Arun District Conservation Area Advisory Panel
c/o Civic Centre

Application No: AB/55/21/L

Site Address: 61 High Street Arundel BN18 9AJ

Description of works: Listed building consent for the removal of the built-in seating, removal of the internal false timber cladding, lowering of height of food service hatch, installation of fold-down access ramp to basement steps, overlay of WC floor materials with single-ply membrane & 1 No. illuminated halo advertisement on front elevation.

DRAWING TITLE  
PROPOSED BASEMENT PLAN, FIRST  
FLOOR PLAN AND FRONT ELEVATION

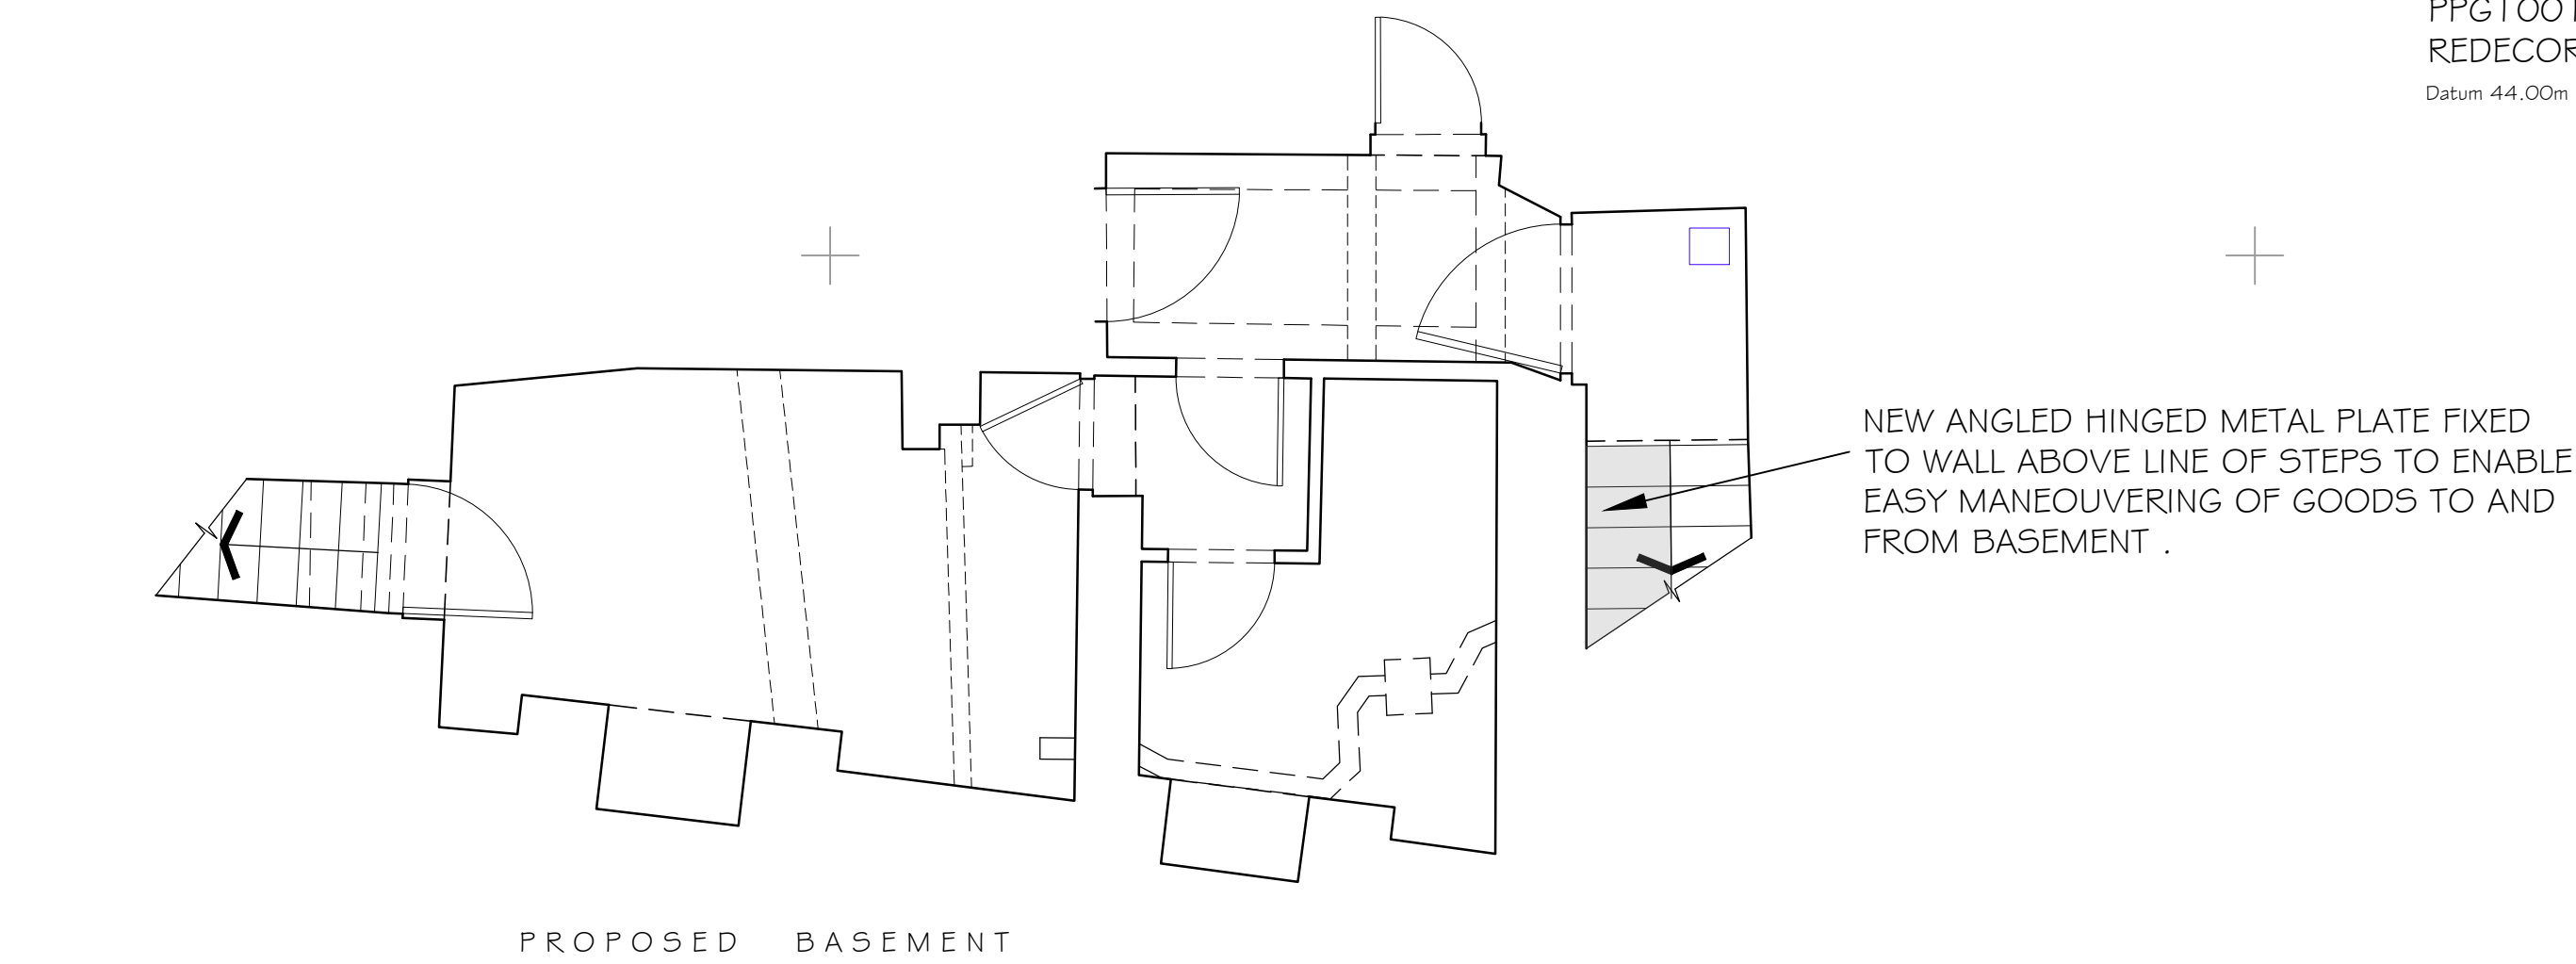
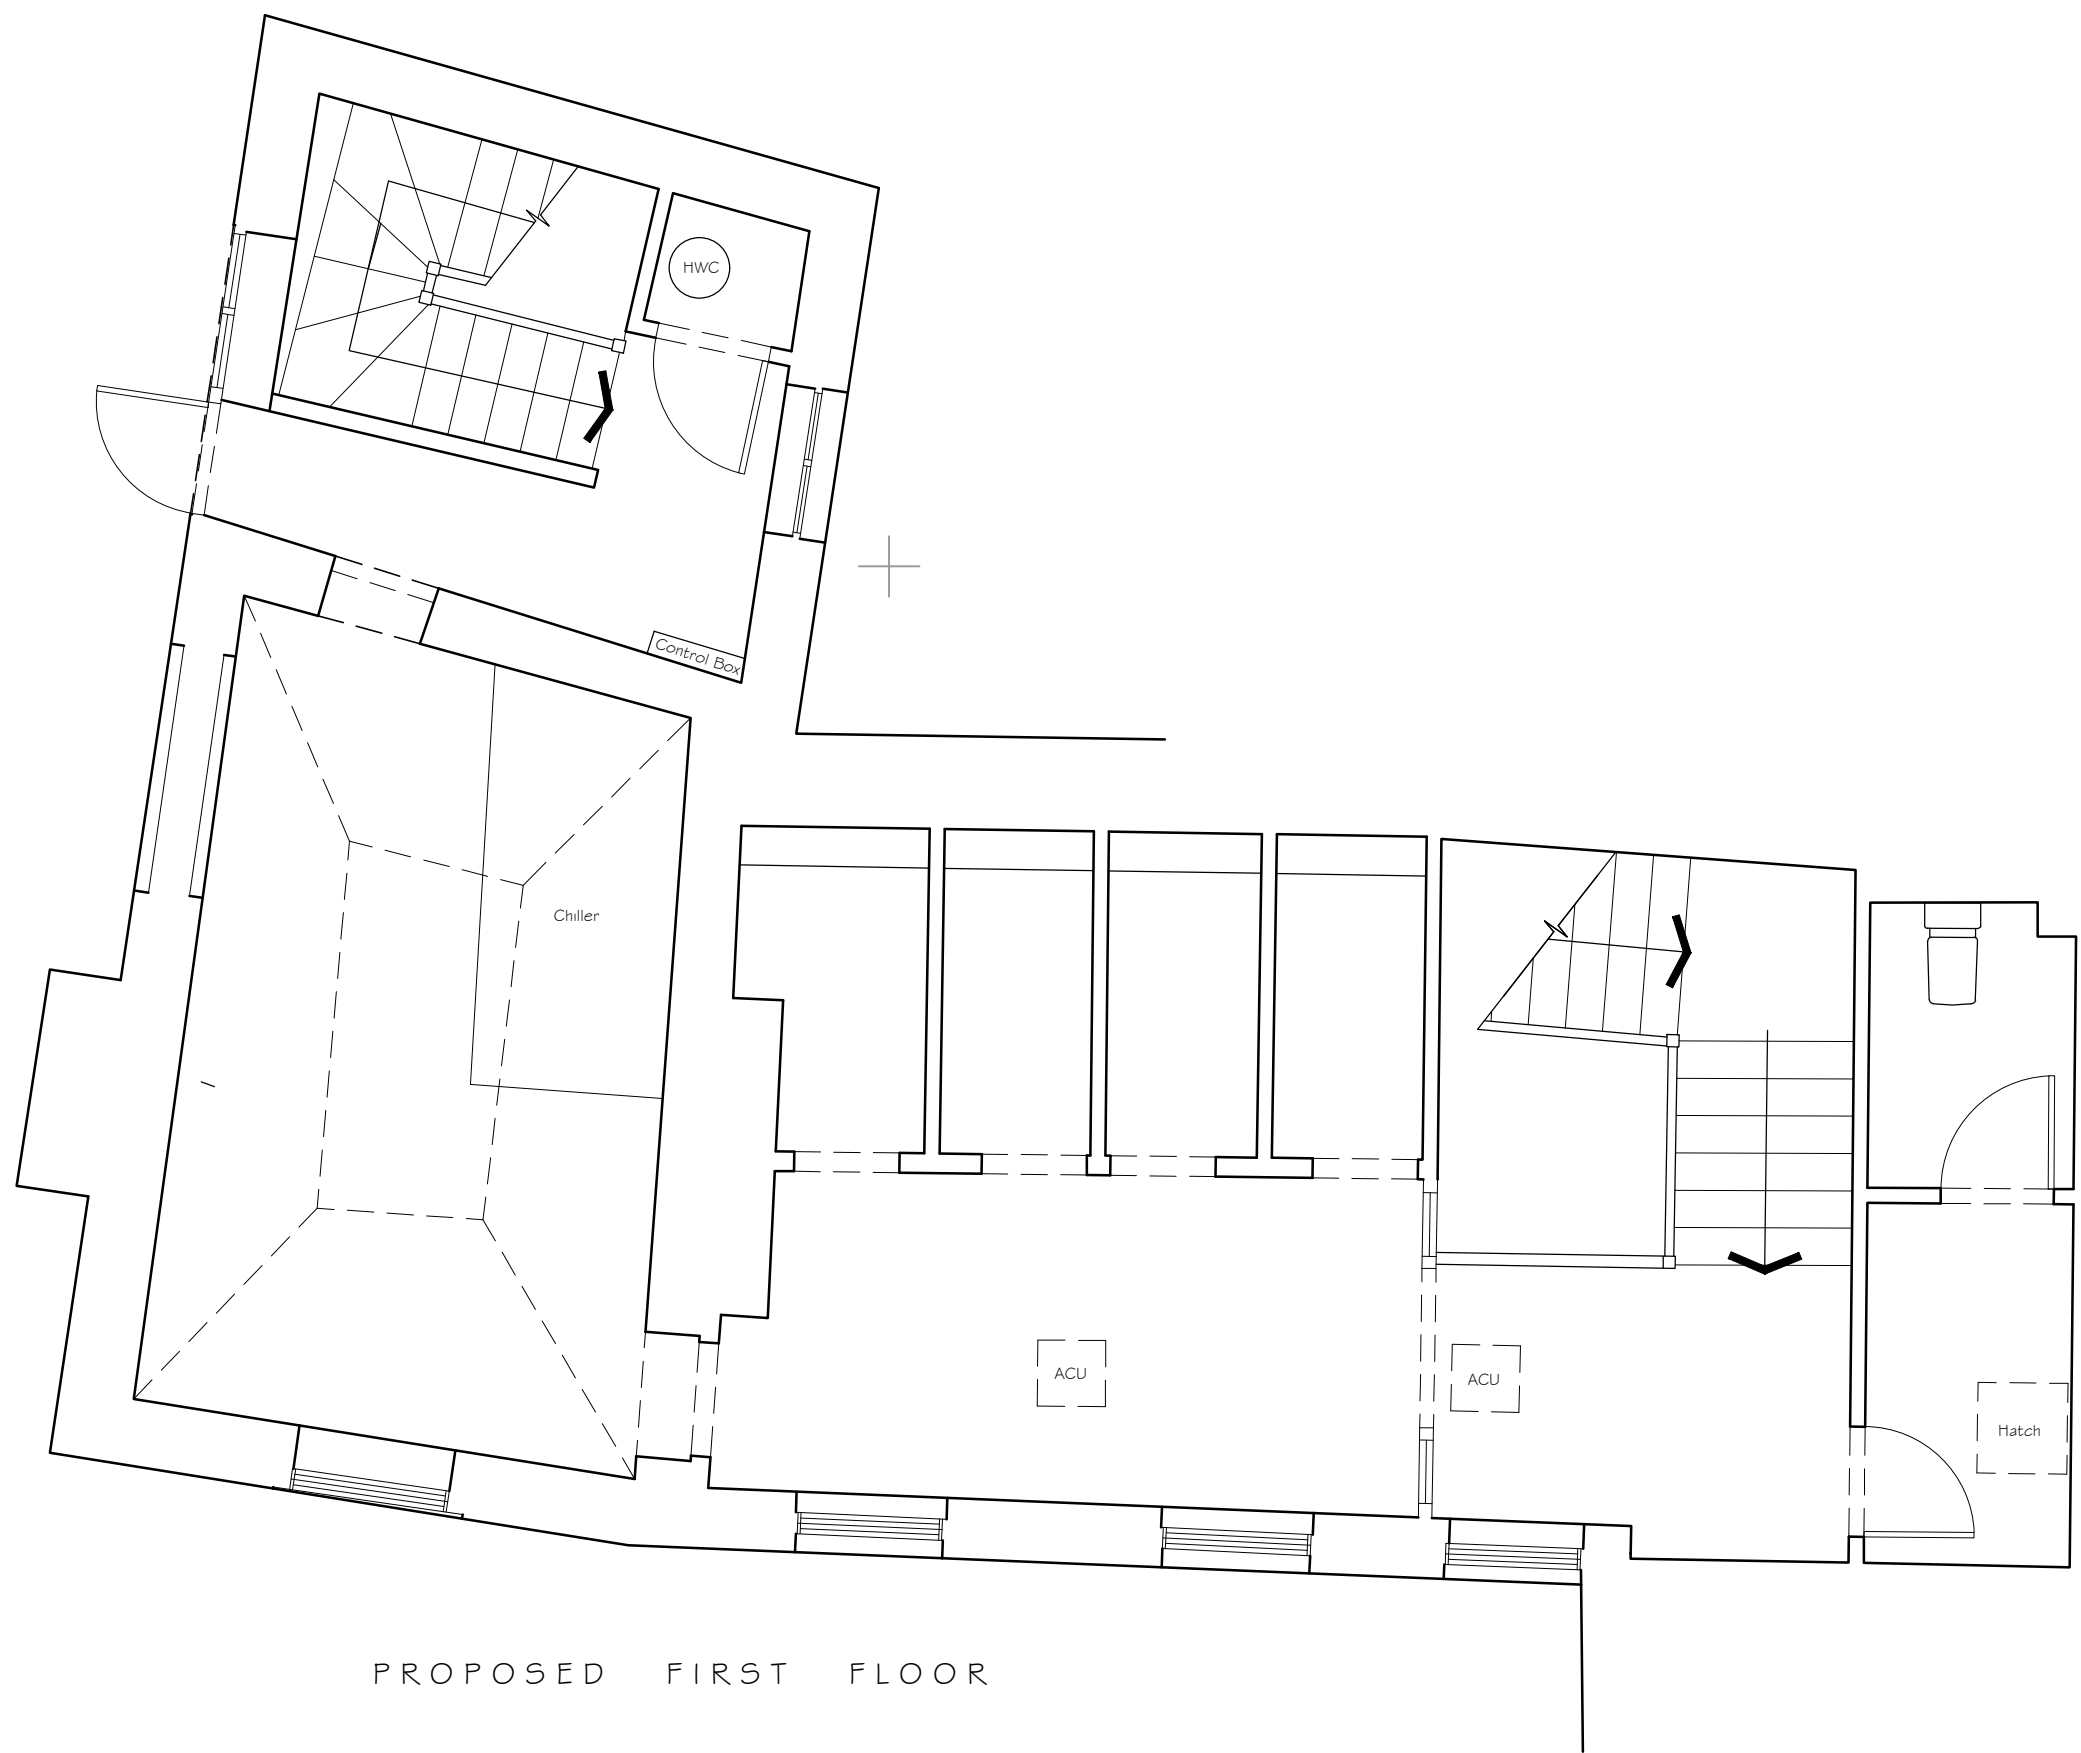
The proposed sign on the front elevation is modest in size and the method of illumination is appropriate so that it will have a neutral effect on the character or appearance of the conservation area.

The new metal fold down access ramp to the basement is likely to be visible at pavement/street level and it is suggested that it be painted black which would then match the colour of the nearby, separately listed, railings.
